AB/119/14/TC -DS.

14, Mastlets Court,
Queen Street,
ARUNDEL.

I am writing in reference to your notice stating the intention of Arun District Council to fell two sycamore ^(T4 and T5) trees at Mastlets Court, Arundel. I am a resident there, at number 14, adjacent to the trees to which your notice refers.

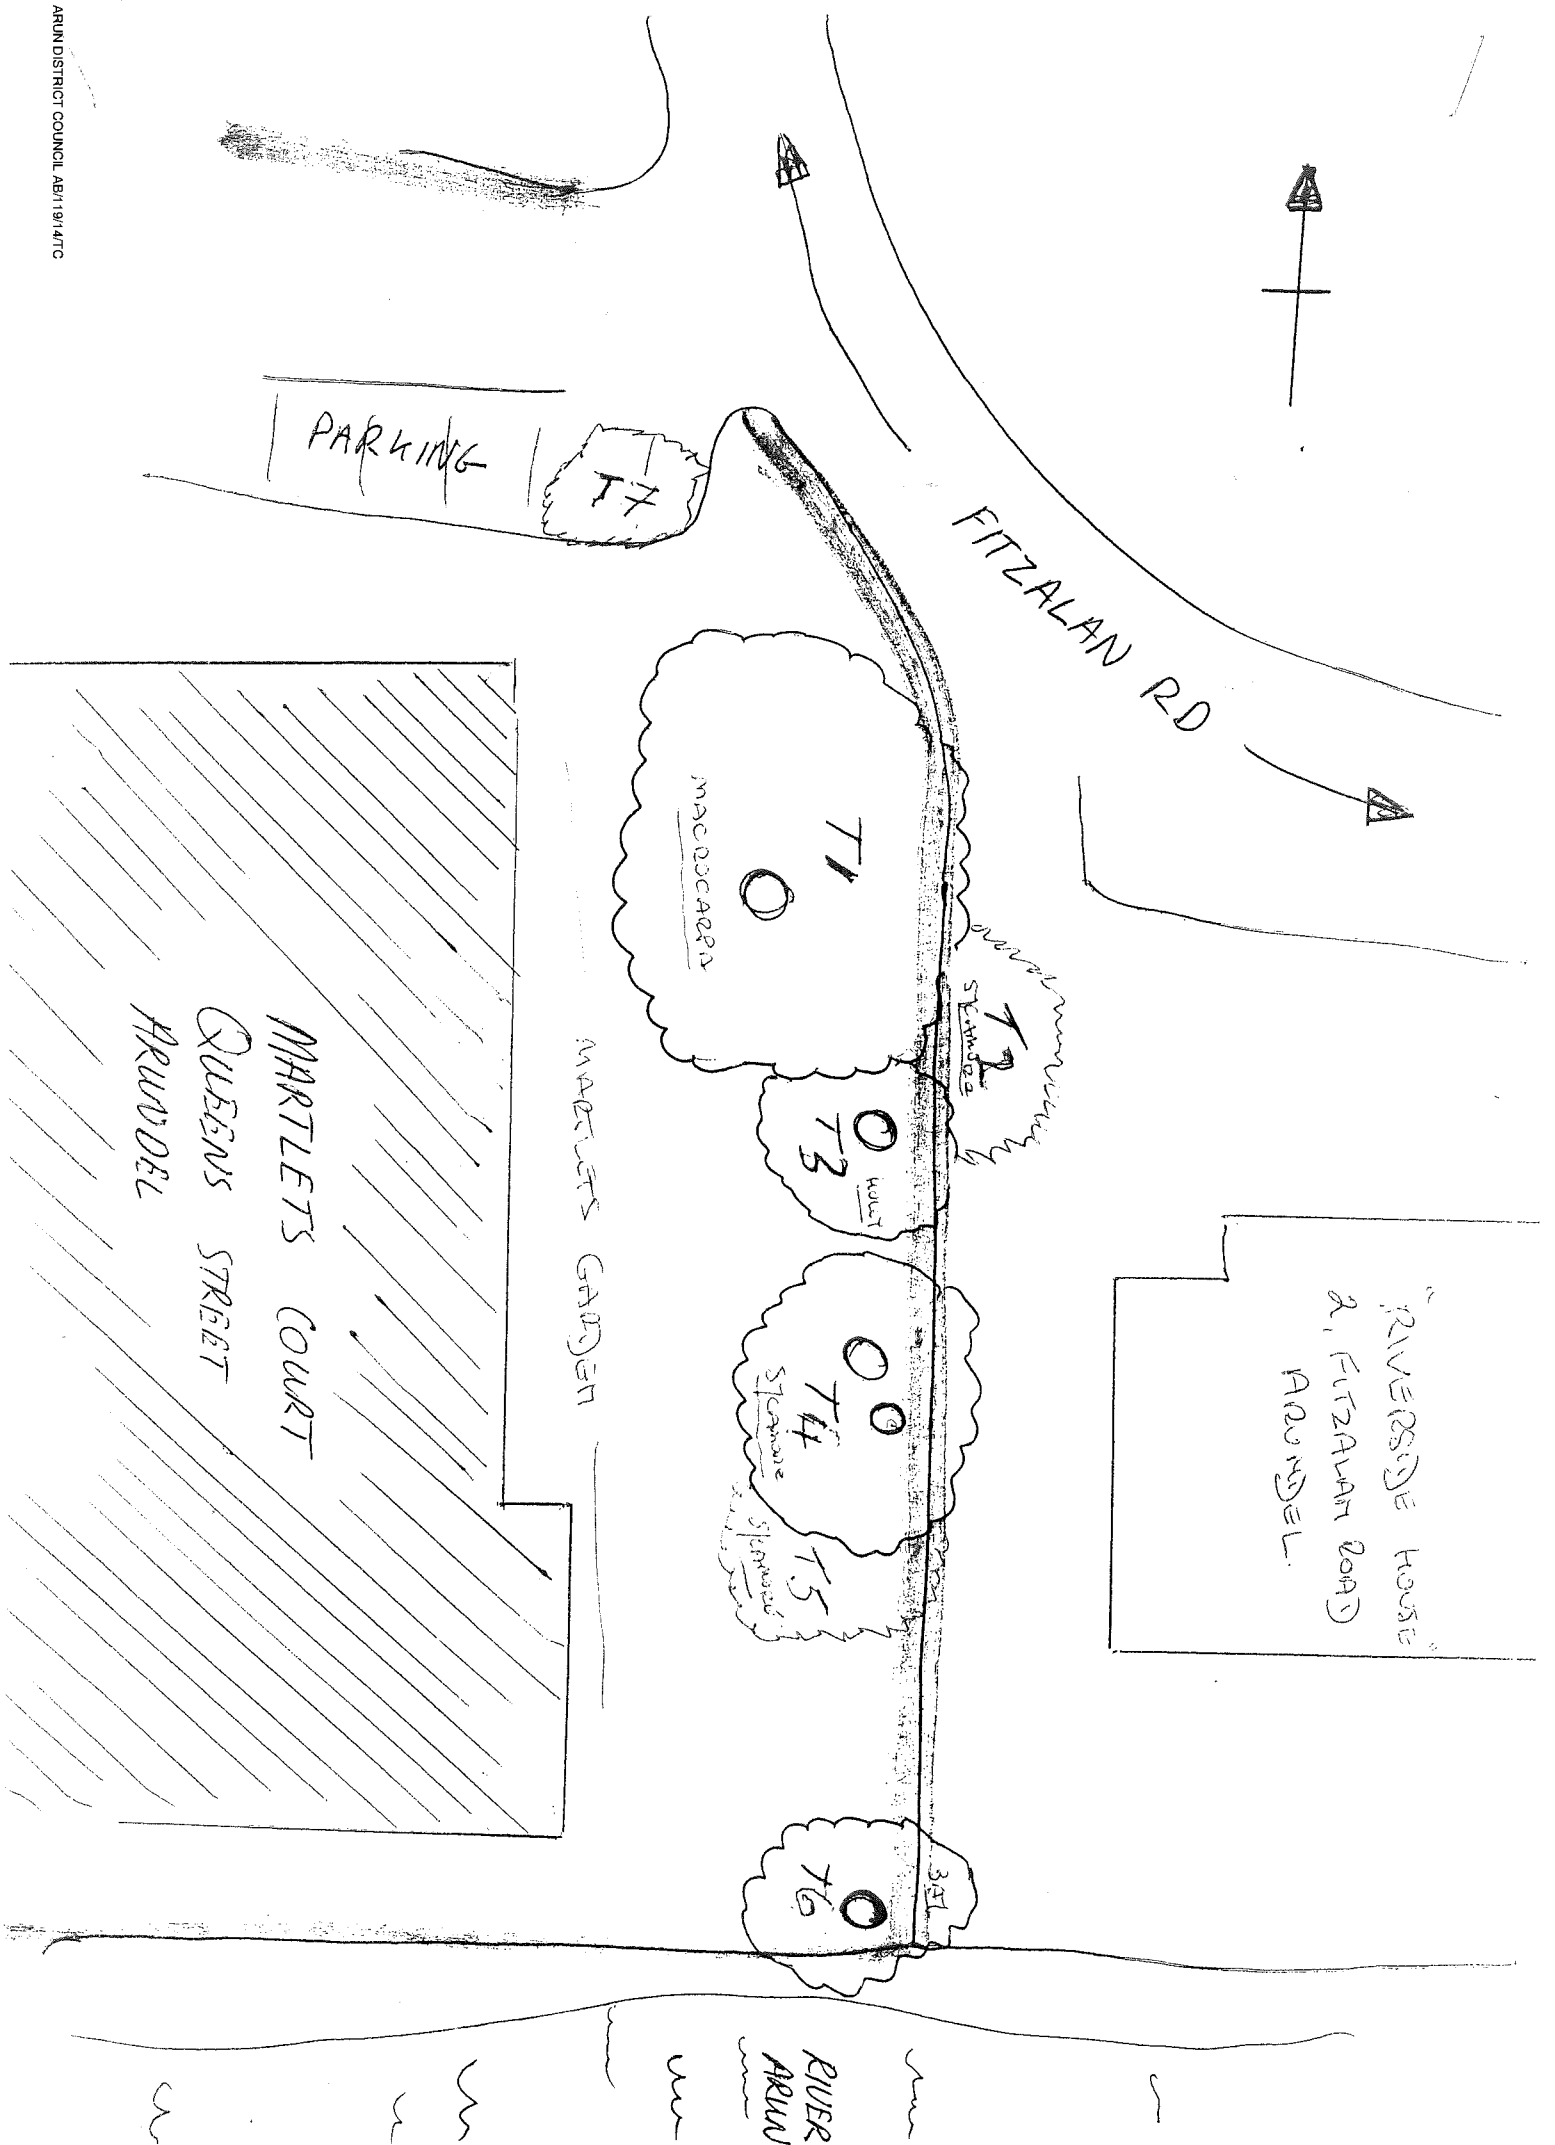
I have examined the site to which your notice refers. There is one, not two sycamore trees to which your notice refers. Adjacent to the sycamore is a deciduous tree not of the same genus. It is an extremely attractive

tree which I believe ^{should} be preserved.
Many of the residents here share my
view, i.e. they wish to keep the tree to
which I refer.
